Reference No:	2024/62/92116/W
Site Address:	20, Hallas Grove, Dalton, Huddersfield, HD5 8ED
Description:	Demolition of existing garage and erection of two storey side extension
Recommending Officer:	Molly Storer

HOUSEHOLDER DELEGATED REPORT

Application Number	2024/92116
Location	20, Hallas Grove, Dalton, Huddersfield, HD5 8ED
Proposal	Demolition of existing garage and erection of two storey side extension
Publicity end date	19 th September 2024
Number of representations received	None.
Kirklees Local Plan Allocation/Designation	Unallocated on the Kirklees Local Plan.
Extension to Time (EoT)	No EoT Date: N/A
Recommendation	Conditional Full Permission

Client Daniel Aspinall		© 08/01/22 Langhus Ltd		
Project 20 Hallas Grove, Dalton - Side Extension				
Drawing Title Proposed - Site Plan				
Drawn By IR	Checked By Checker	Date 08/01/22	Project Number 2022-000	AS (@ A3) indicated
Status PLANNING			Drawing Number PL-DR-20-12	Rev A

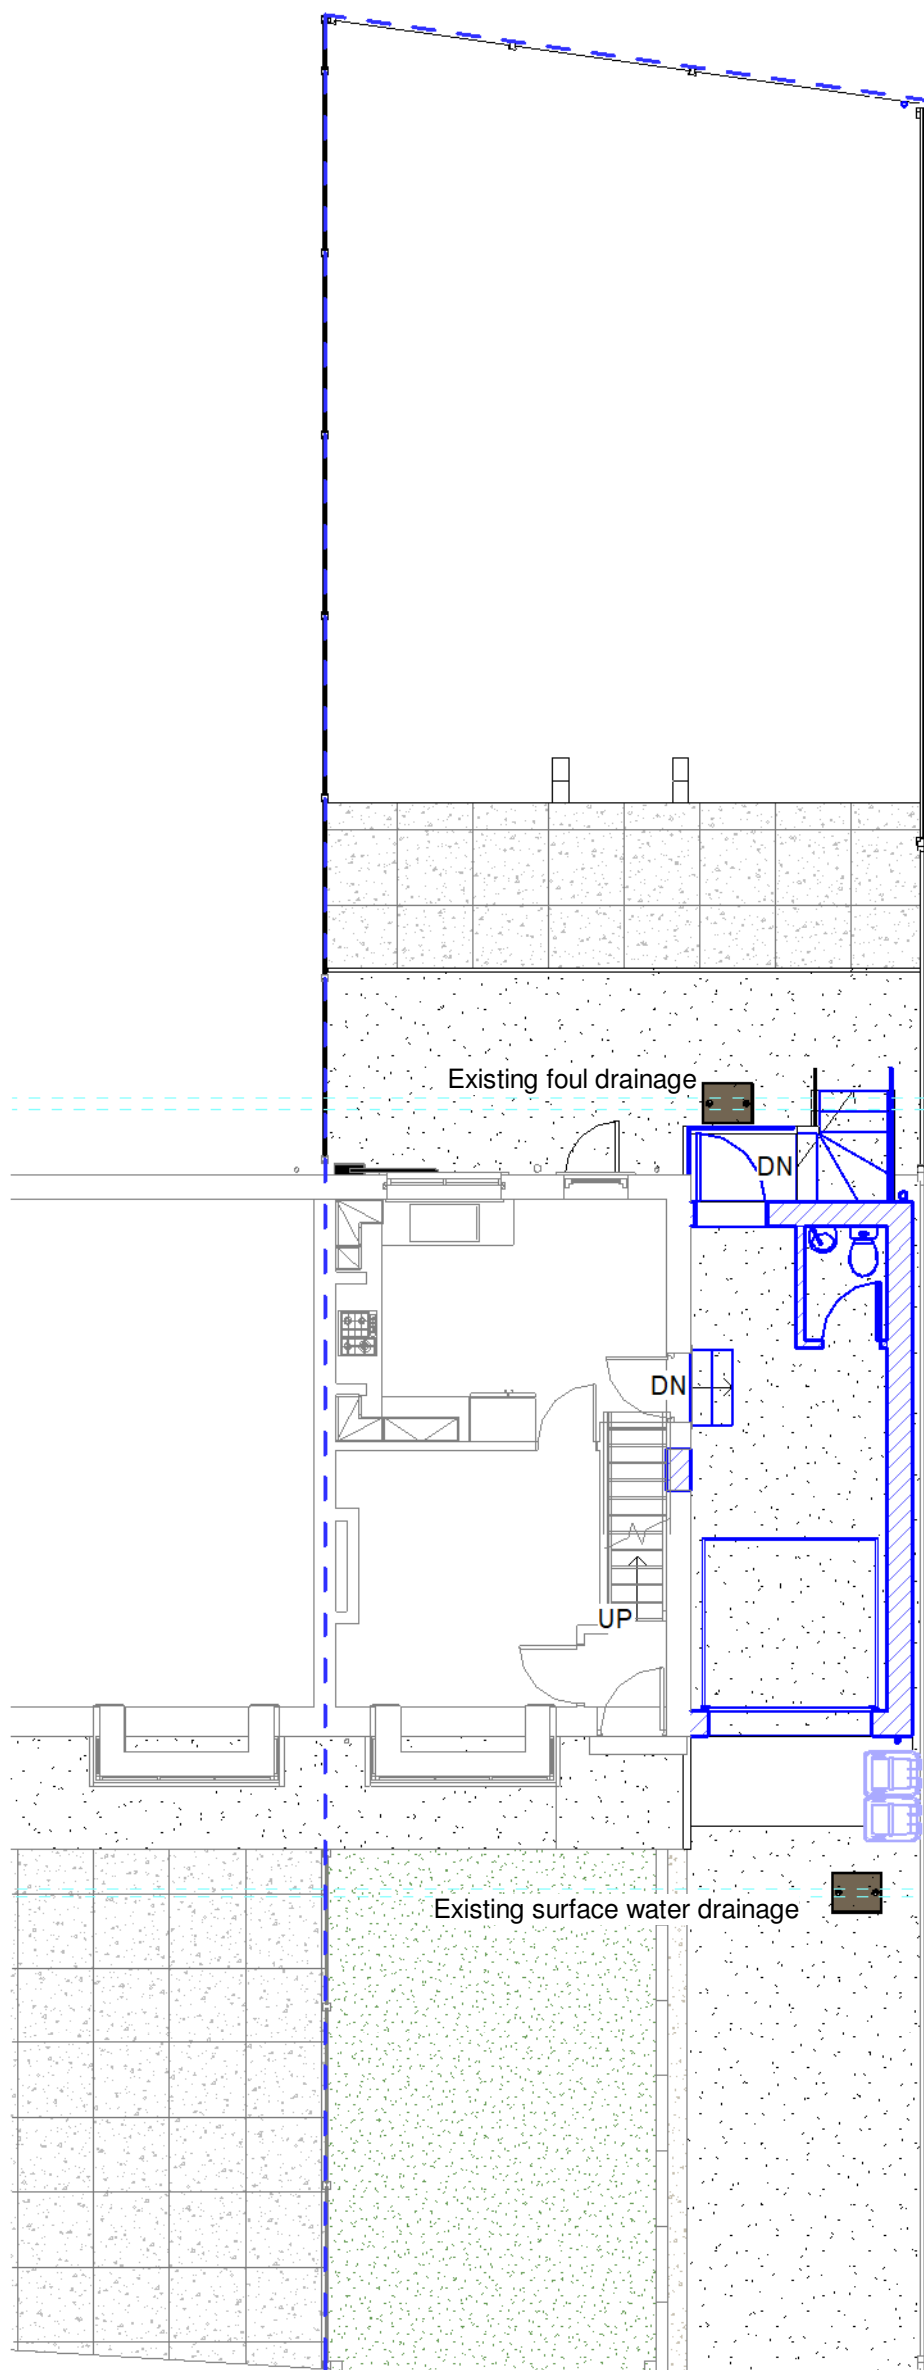
Two-storey side extensions should:	<u>Yes - COMPLY</u>	<u>No - JUSTIFY</u>
Not take up all or most of the space to the side of a house		The proposed side extension would be built up to the side boundary resulting in no space remaining to the side of the dwelling. However, given the property is an

end terraced dwelling and the street scene consists of terraced house types (including other end of terrace dwellings with side extensions), the two-storey extension would not create an unusual nor incongruous appearance within the street-scene or detract from the overall appearance of the host dwelling. There would be access to the rear garden through the proposed garage on the ground floor.
Maintain a 1 metre gap to the side boundary to ensure the building is not too close to a neighbouring property		The proposed extension would be built on the site boundary and therefore a 1 metre gap to the side boundary would not be maintained. Whilst not compliant with SPD guidance, this is not uncommon with in the street scene and therefore would not be out of place. There are also no windows proposed within the side elevation and would most likely face non-habitable room windows at the neighbouring property.

Remaining garden space of application property	• KDP 7 of the SPD • Policy LP24 Design (b) and (c) • Chapter 12 of the NPPF	Whilst the proposed extension would take up the space to the side of the dwelling, there would be adequate outdoor space retained for current and potential future occupants, therefore the proposal is acceptable in this regard.	✓

Client		Daniel Aspinall		
Project		20 Hallas Grove, Dalton - Side Extension		
Drawing Title		Proposed - Elevations		
Drawn By	Checked By	Date	Project Number	Sc:As@ A1
IR	Checker	08/02/22	2022-000	indicated
Status	Drawing Number	Rev		
PLANNING	PL-DR-25-14	A

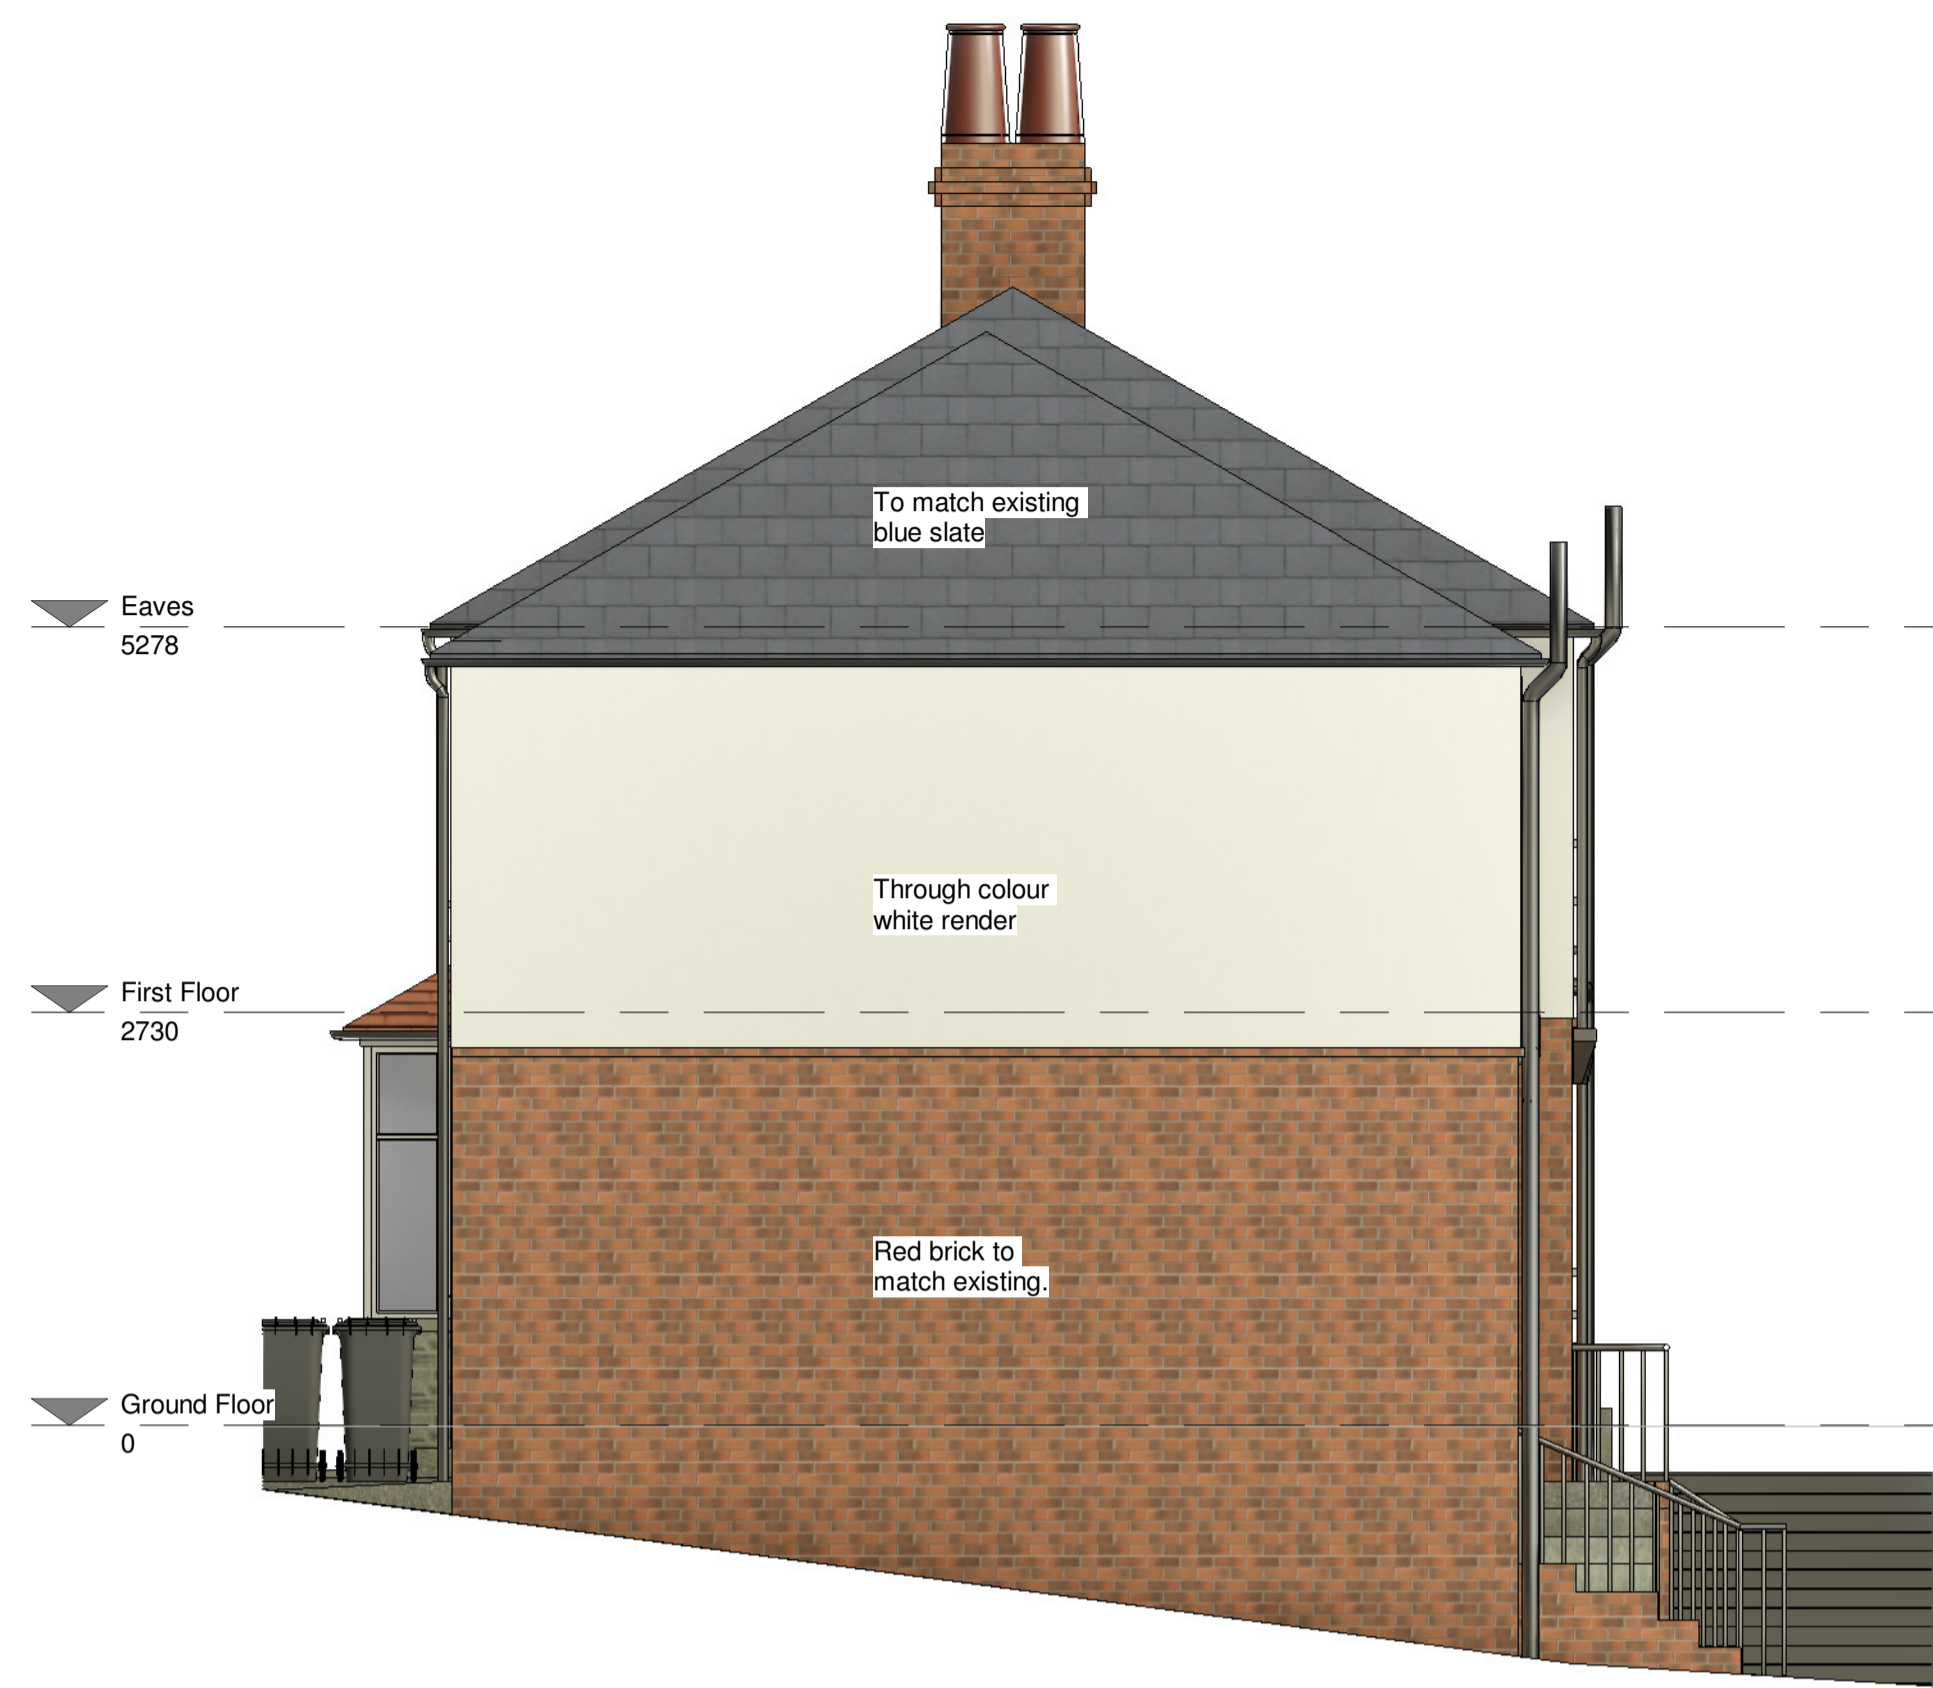
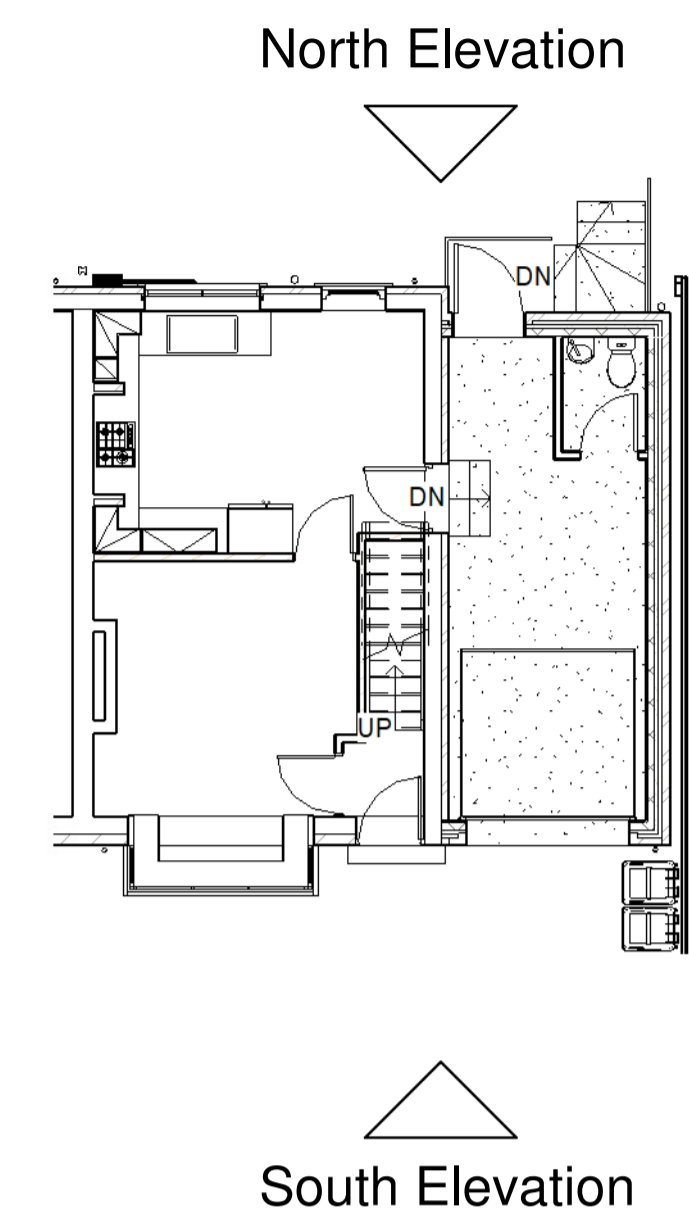
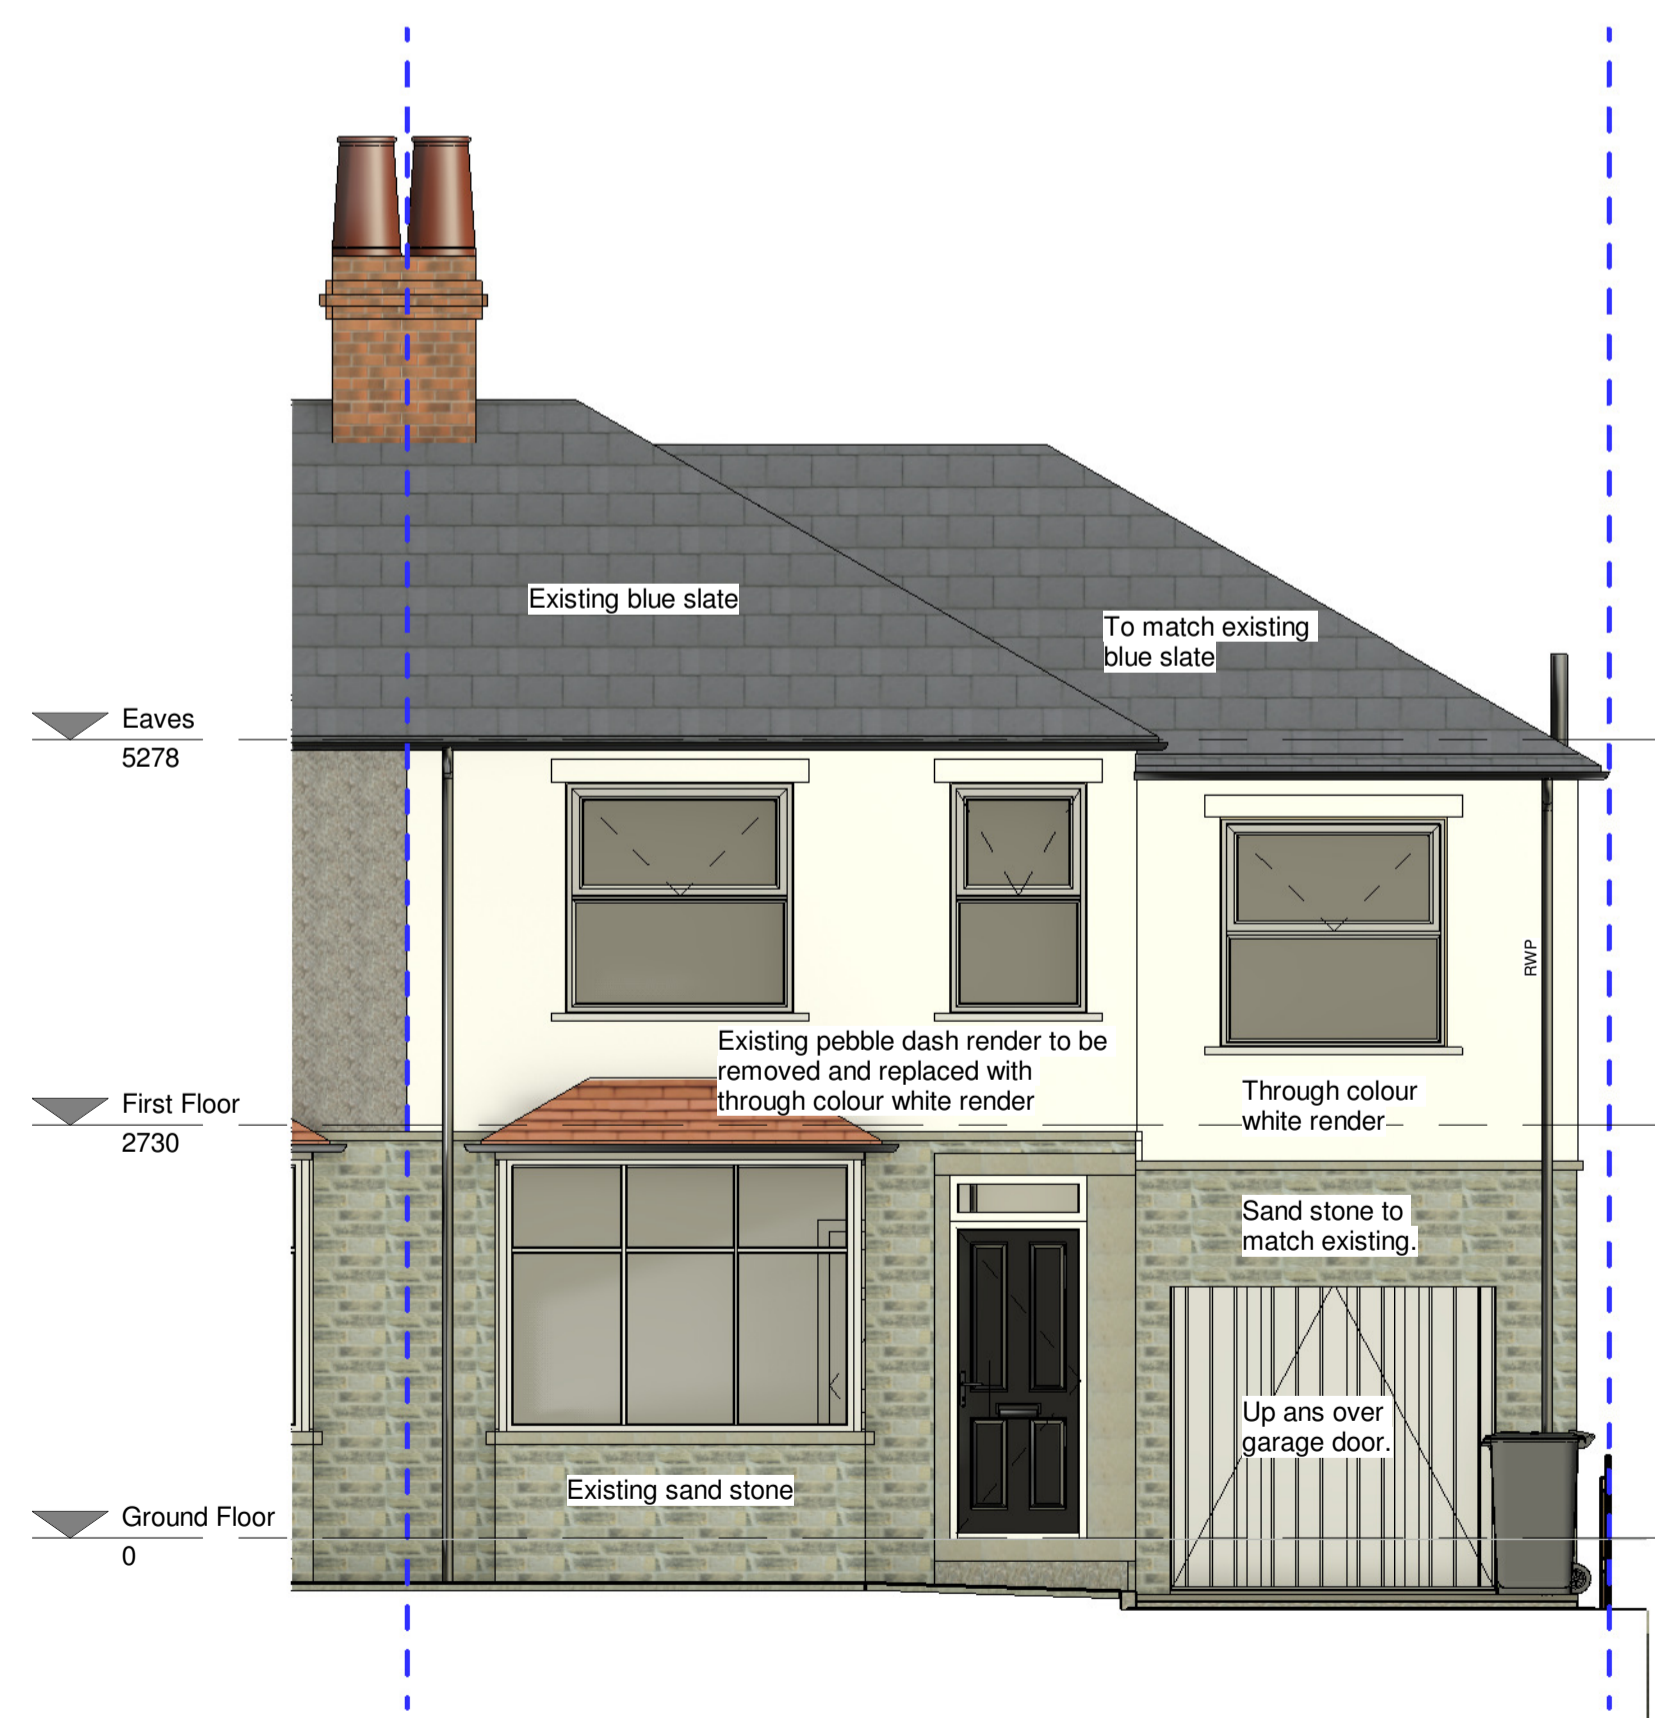
Be set back at least 500mm from the front wall of the house		The front elevation of the side extension would align with the front elevation of the existing house. However, given that the roof is set down by 500mm and that other properties on the street have side elevations which align with the

front elevation of the existing house, the impact of the proposal having regard to this criterion would be acceptable. It should also be noted that the house has an existing forward projection in the form of a bay window. The proposed extension would be set behind this further acting to alleviate any adverse harm.
--	--	---

Facing materials and detailing	• KDP 9 of the SPD • Policy LP24 Design (d) (iii) of the KLP • Chapter 12 of the NPPF	The proposed extension would be constructed from red brick, sandstone and white render to match the existing. In the event that planning permission is approved, it is recommended this is secured by condition.	✓
Roof style	• KDP 1 and 2 of the SPD • Policy LP24 Design (a), (c)	The proposed roof style would match that of the host dwelling and other neighbouring properties. The roof would be	✓

and (d) of the KLP • Chapter 12 of the NPPF	constructed from blue slate tiles which matches the materials used on the host dwelling roof. In the event that planning permission is approved, it is recommended this is secured by condition.	
Window proportions	• KDP 1 and 2 of the SPD • Policy LP24 Design (a), (c) and (d) of the KLP • Chapter 12 of the NPPF	The windows proposed within the extension match the size and type used within the host dwelling. There will be no windows in the side elevation. The rear will have a single door at ground floor and a single window at first floor level. The front elevation will have a garage door on the ground floor and a single window on at the first floor level.	✓
Accessibility for all users	• KDP 17 of the SPD • Policy LP24 Design (f) • Chapter 12 of the NPPF	Accessibility to the rear garden would be gained through the dwelling.	✓
